**From:** Zac Denton  
**Sent:** 12 December 2018 08:29  
**To:** Planning.Responses  
**Subject:** FW: Planning Application Ref: R/197/18/HH – 1 Pigeonhouse Lane (1PL) , Rustington

**Planning Application Ref: R/197/18/HH – 1 Pigeonhouse Lane (1PL) , Rustington**

Drawing Title: PROPOSED ELEVATIONS

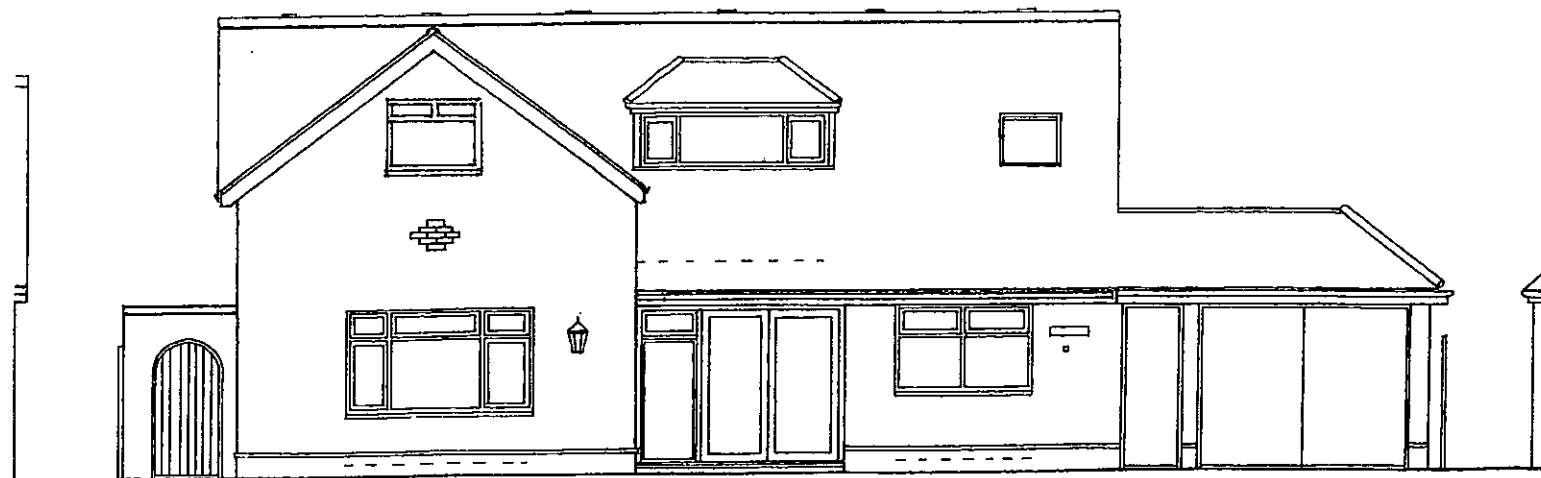
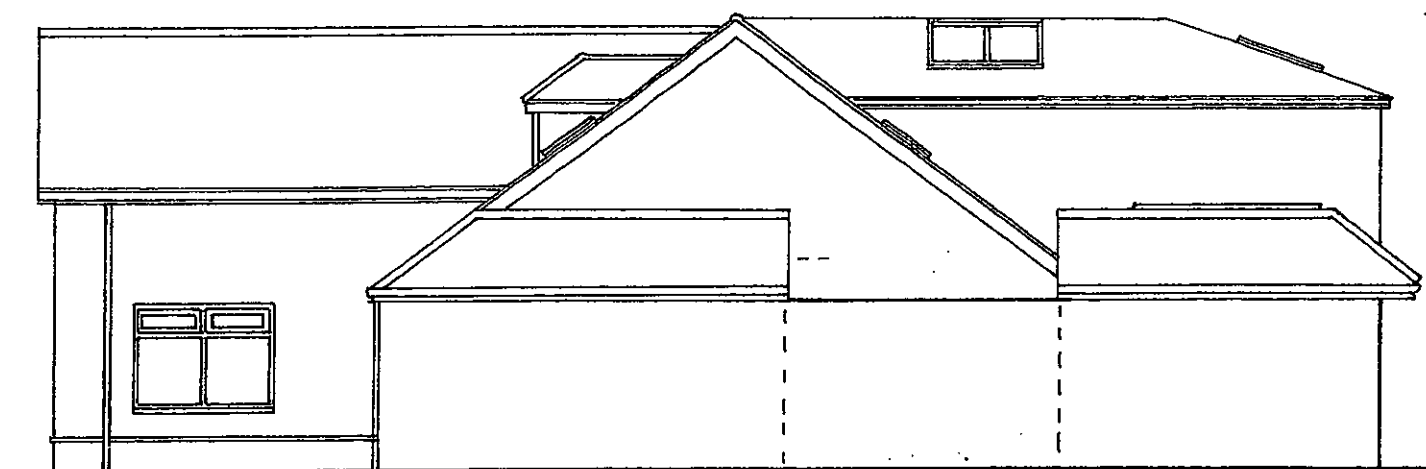
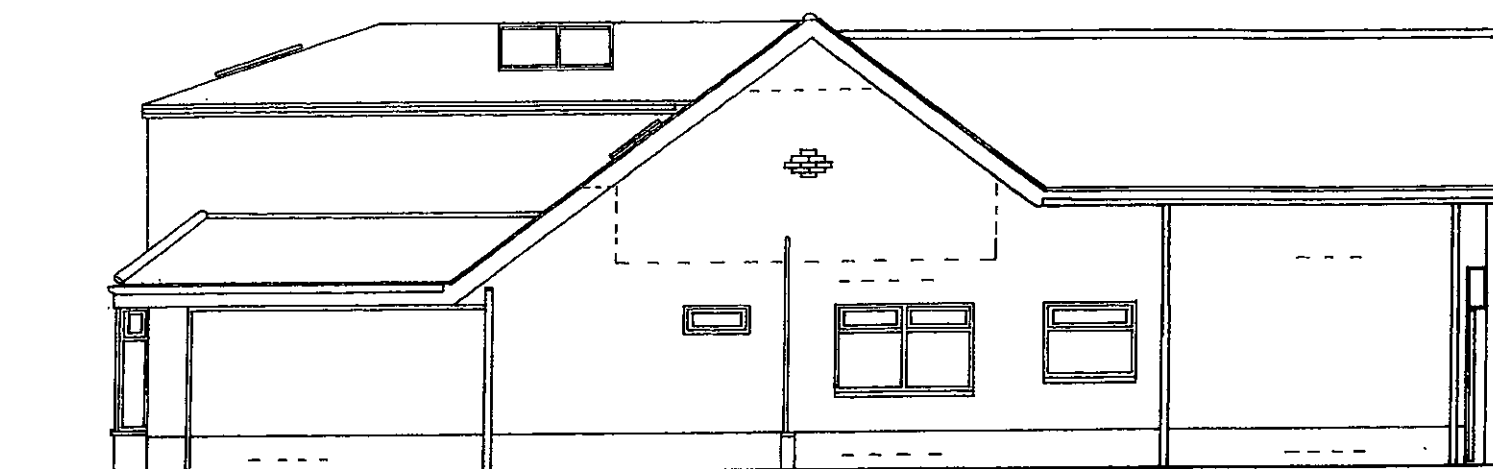
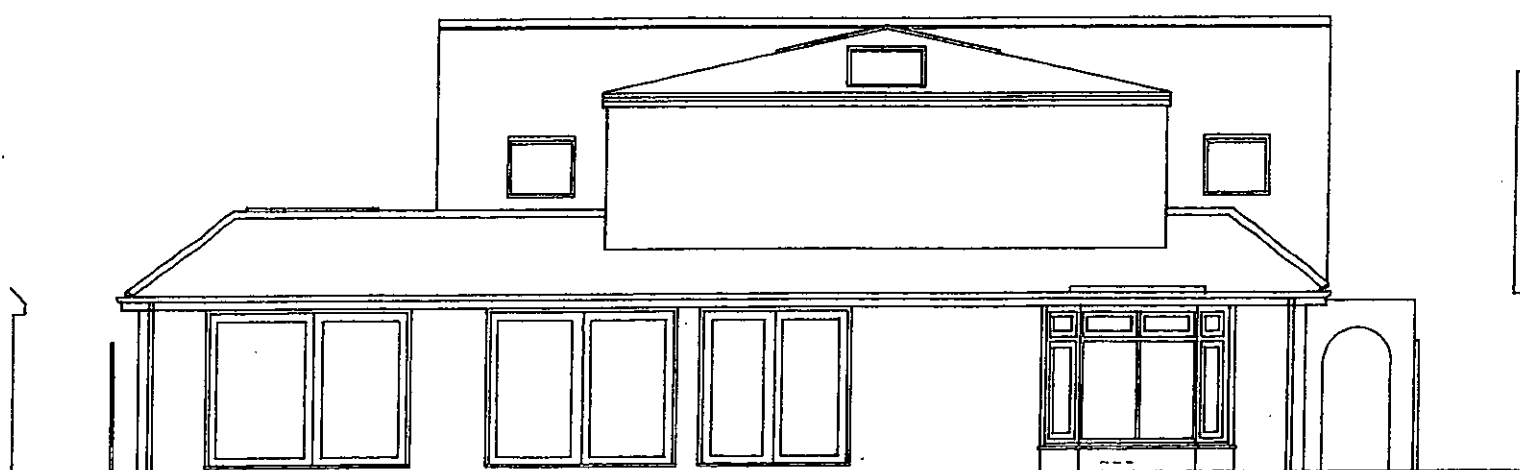
given the very close proximity of 1PL directly to the south the proposed substantial increase in the roof height and “vertical extension” to the overall roof length would result in a very significant reduction to our natural daylight and sunlight, as well as causing overshadowing and an overhanging effect which would be seriously harmful to our living conditions.

Drawing Title: PROPOSED FIRST FLOOR PLAN

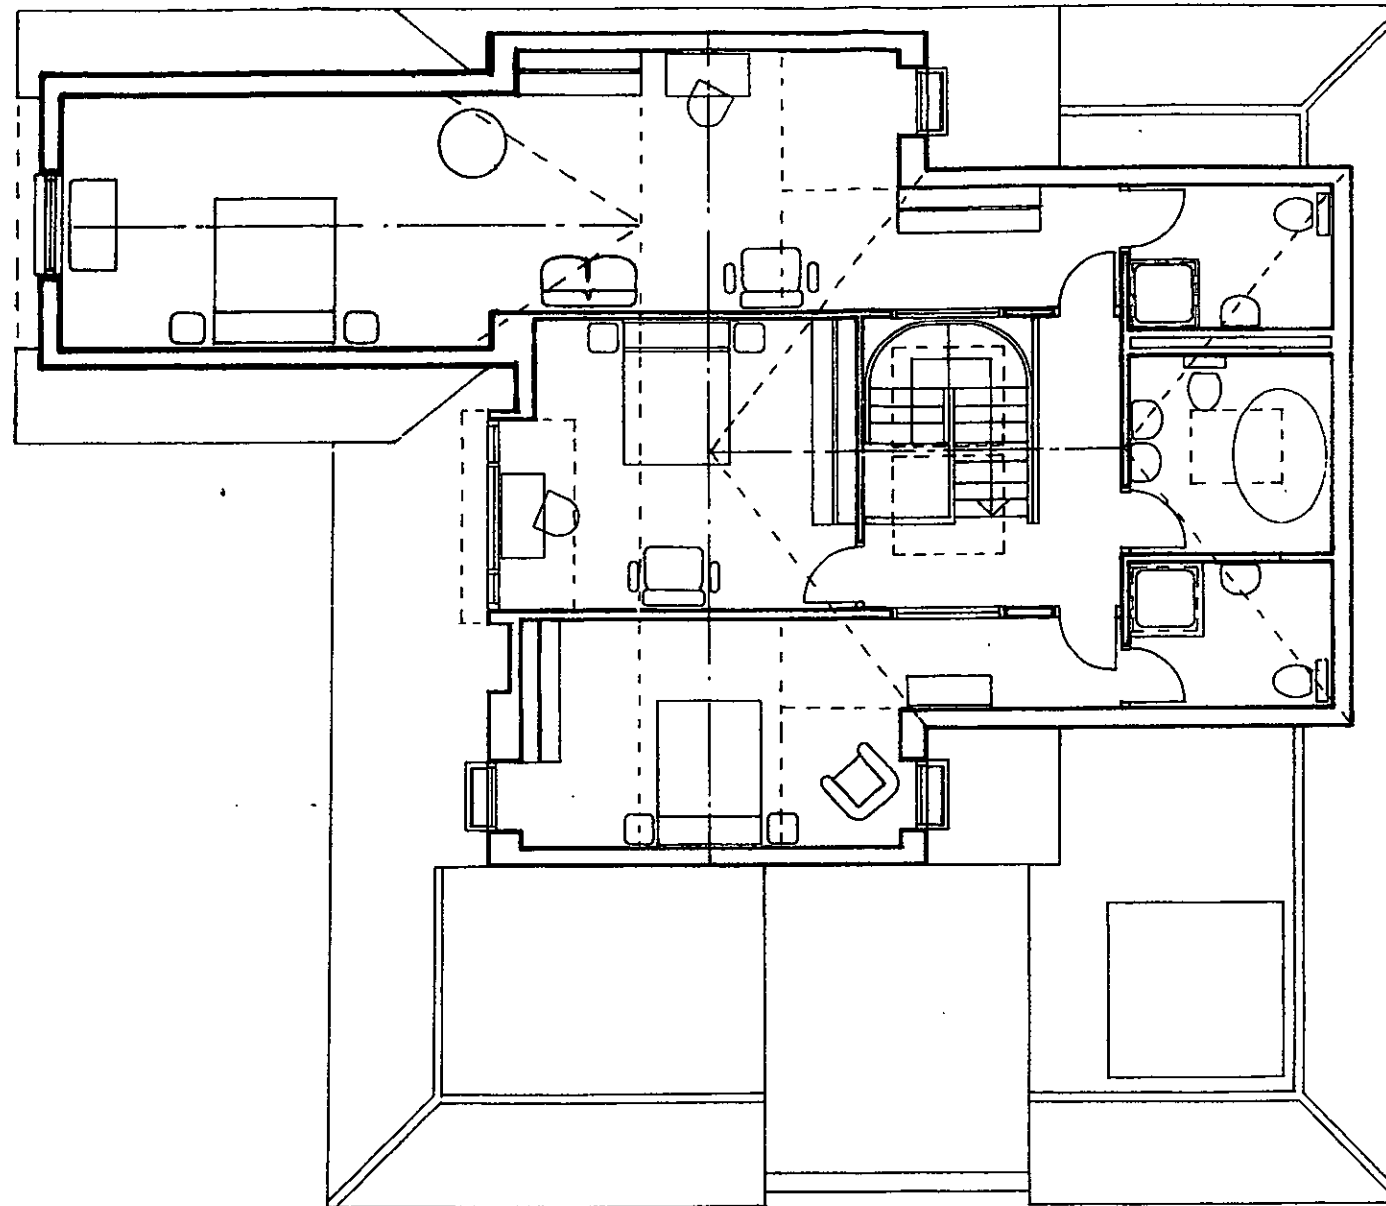
The proposals to alter the window closest to our property in the rear first floor extension would create direct overlooking into our south lounge window which is an unacceptable intrusion on our privacy.
